**WELWYN HATFIELD COUNCIL – DEVELOPMENT CONTROL**  
**DELEGATED REPORT**

<b>APPLICATION No:</b>	<b>S6/2007/1117/FP</b>
------------------------	------------------------

The proposed development would involve the erection of side extensions to the front and rear of the southern flank elevation. The roof of the main dwelling would be extended above these single storey additions to create larger part gable ended front and rear elevations. To the northern elevation the existing dormer would be extended to have a width of 9.3m. To the southern flank plan of the roof a dormer style addition would be constructed with three segments above the ground floor area which differs in width.

Proposed North Elevation

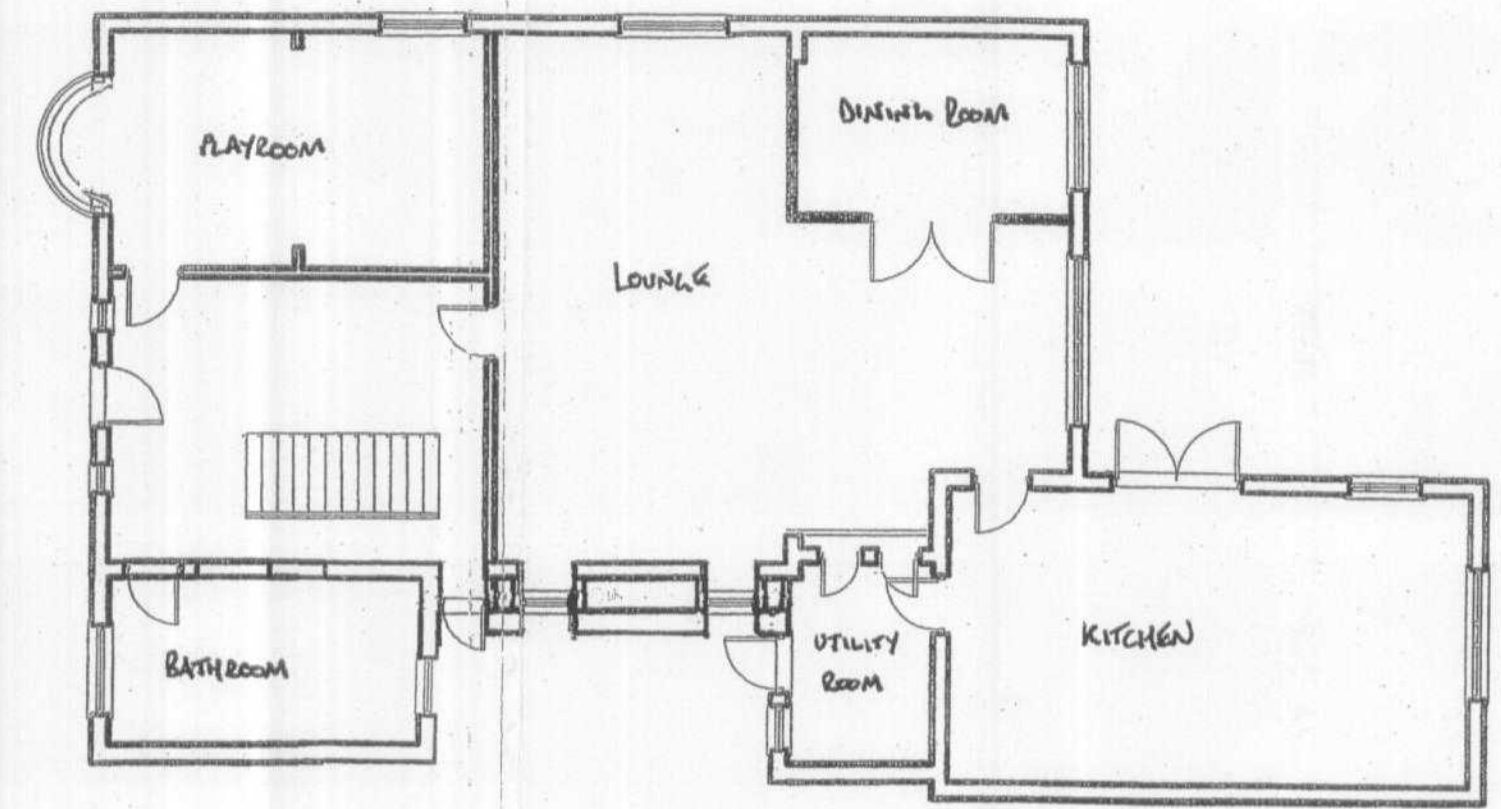
The proposed development would result in further overlooking of the neighbouring dwelling to the north. Although there are existing ground floor windows facing the adjacent property to the north, the proposed development would result in three casements being positioned at roof level. These elevated windows would allow a view downwards into the kitchen/diner and side of the neighbouring property, as a result this adjacent property would suffer an unacceptable degree of direct and perceived overlooking.

- 2 The proposed development would adversely affect the amenity of the occupiers of the adjoining property at No.9 by reason of the proposed windows at roof level facing north and consequent loss of privacy. The proposal would not therefore achieve an adequately high standard of environment and would be contrary to the provisions of Policies D1 and D2 of the Welwyn Hatfield District Plan 2005.

Proposed South Elevation

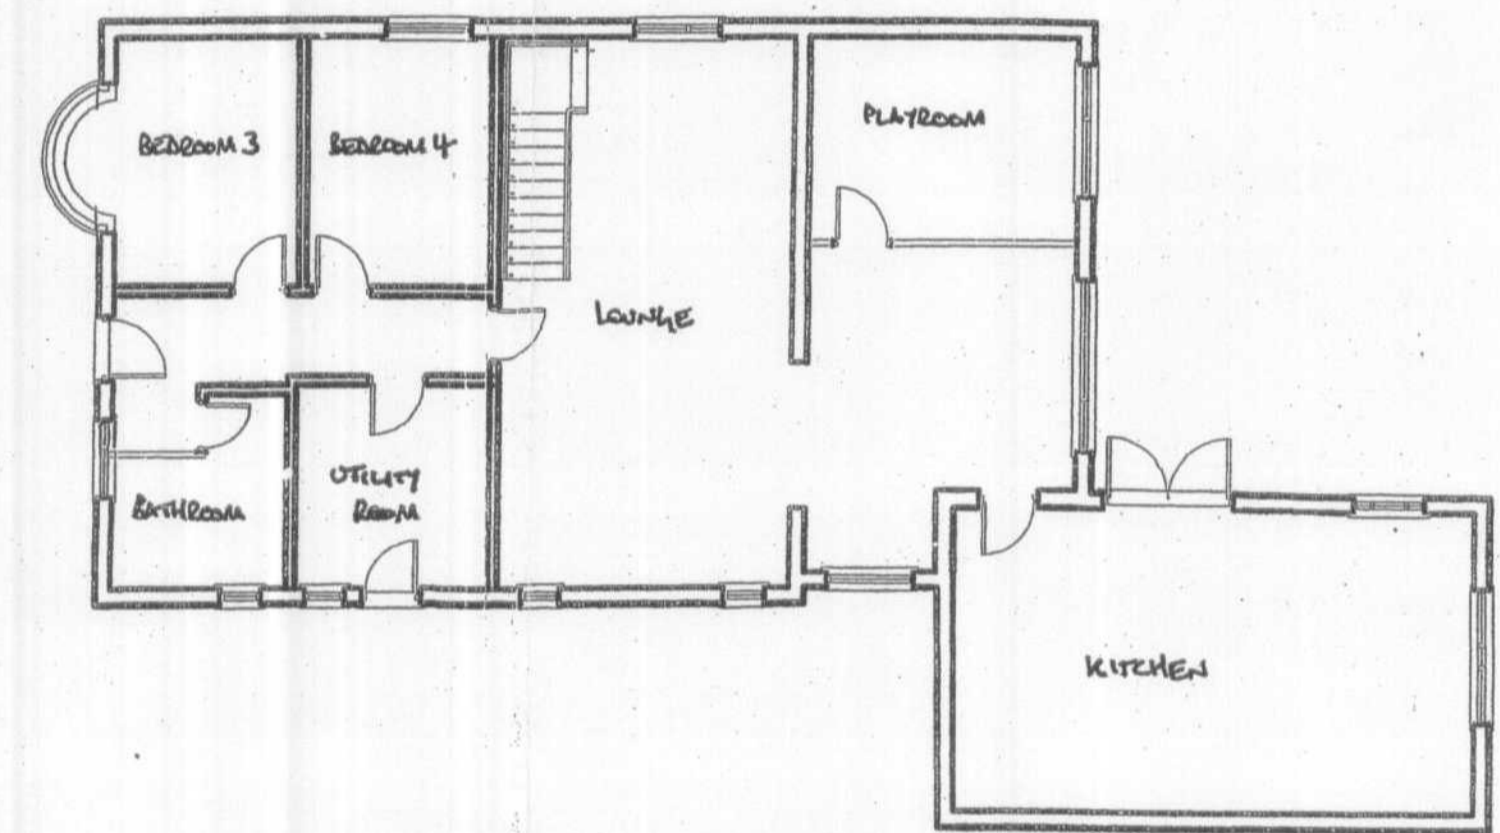
2. To the southern flank of the dwelling extensions which would align the boundary have previously been refused and dismissed at appeal under application S6/2005/1056/FP. The proposed development has attempted to overcome this appeal decision by arranging two projections either side of the neighbouring properties flank windows. Due to the extent of the roof additions above the proposed extensions the impact upon number 13 would be unacceptable and similar to the proposed development within application S6/2005/1056/FP. Although these additions would not necessarily result in a loss of direct sunlight, they would have an overbearing and overshadowing impact which would directly affect the residential amenity of No13's adjacent habitable rooms.

- 3 The proposal would adversely affect the amenity of the occupiers of the adjacent property (No. 13 Theobalds Road) by reason of overdevelopment on this site. This development would have an overbearing impact on neighbouring occupiers and also would result in a significant loss of light to habitable rooms of this property. This is contrary to the Policies D1 and of the Welwyn Hatfield District Plan 2005

Proposed West Elevation

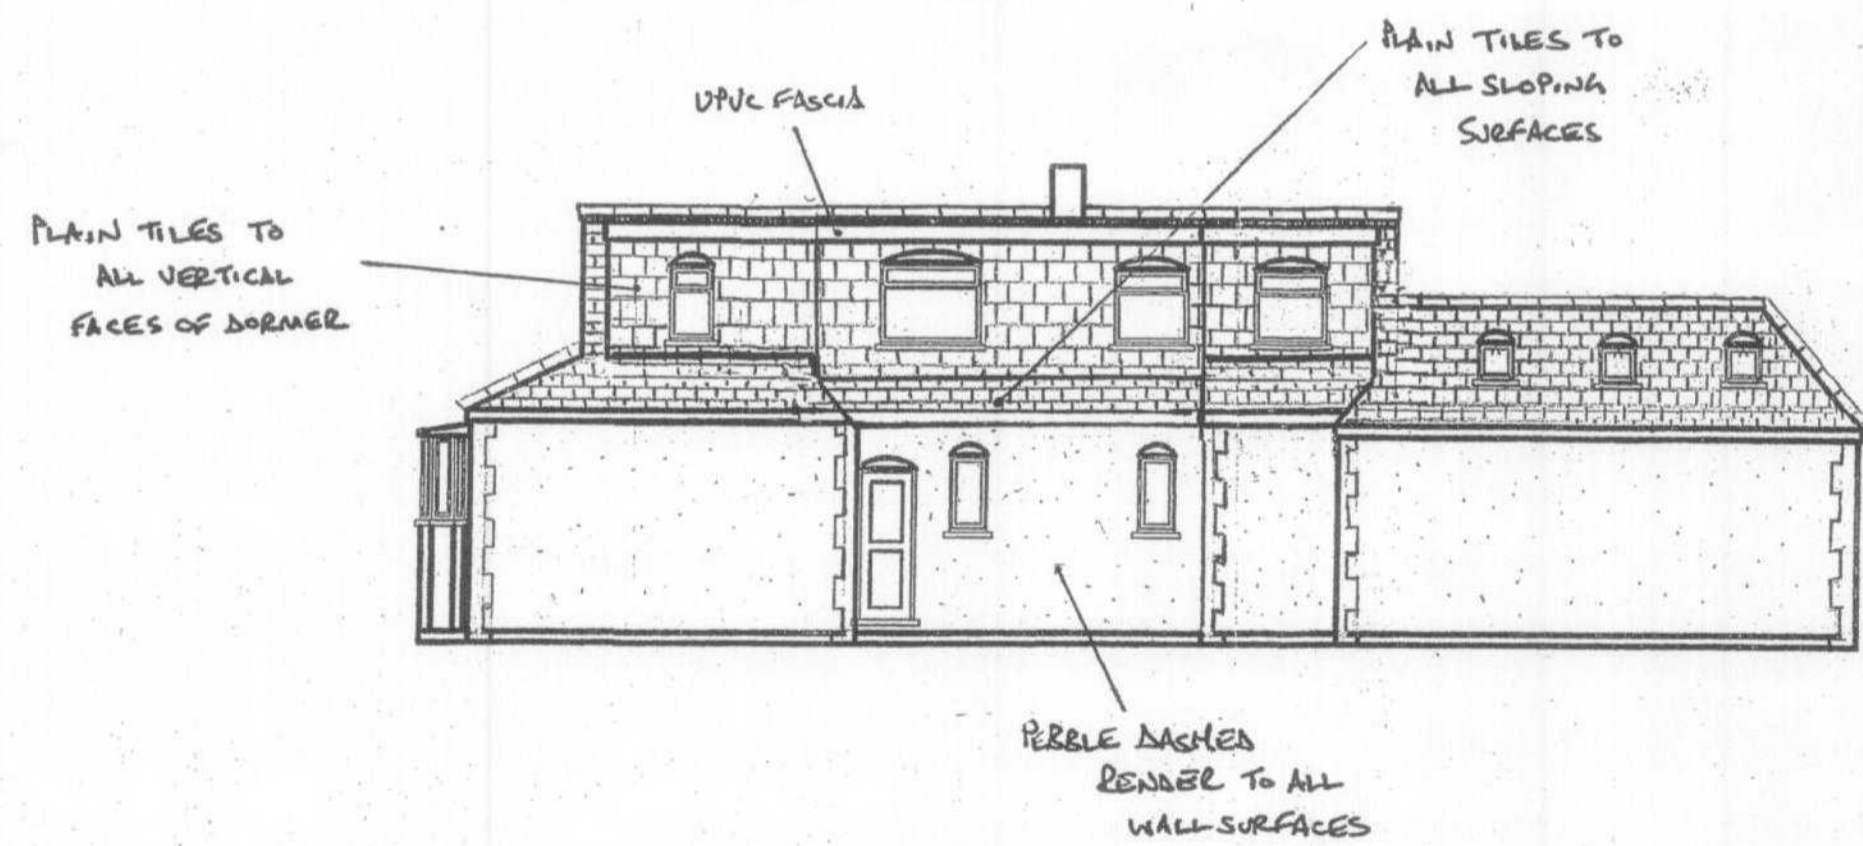
1. The proposed development would involve roof alterations and extensions that would be visible from the front of the dwelling. The proposed development would create sections of flat roof to the top of the main roof. The existing part-gabled front elevation would be extended in width by 2.0m. To the side planes of the roof the existing flat roof dormers would be extended in width to be close to the front plane elevation. The proposed dormer additions to the southern plan of the main roof would consist of additions on different roof plans which would complicate the design of this elevation and give it a cramped and awkward appearance. The combination of additions visible within the street scene to the front of the dwelling would make the application dwelling particularly prominent. The application dwelling has had previous extensions which have altered its design, however, the existing building still

retains some key features of the original dwelling. It has been acknowledged that there are variations in the design of properties within Theobalds Road. However, the street scene surrounding the application dwelling comprises mostly detached bungalows with hipped roof and subordinated additions, particularly the stretch of bungalows from number 11 to Station Road. An important feature which these properties have retained is their original roof form and the main ridge of the dwelling and the roof additions have remained subordinate to the main roof. The proposed development would appear prominent and incongruous within the street scene.

- 1 The proposed roof enlargement and side dormer windows would result in a visually intrusive and bulky form of development which would be out of keeping with, and detrimental to, the character and appearance of the existing dwelling and would adversely affect the character of the surrounding area. The proposal is therefore contrary to Policies D1 and D2 of the Welwyn Hatfield District Plan 2005.
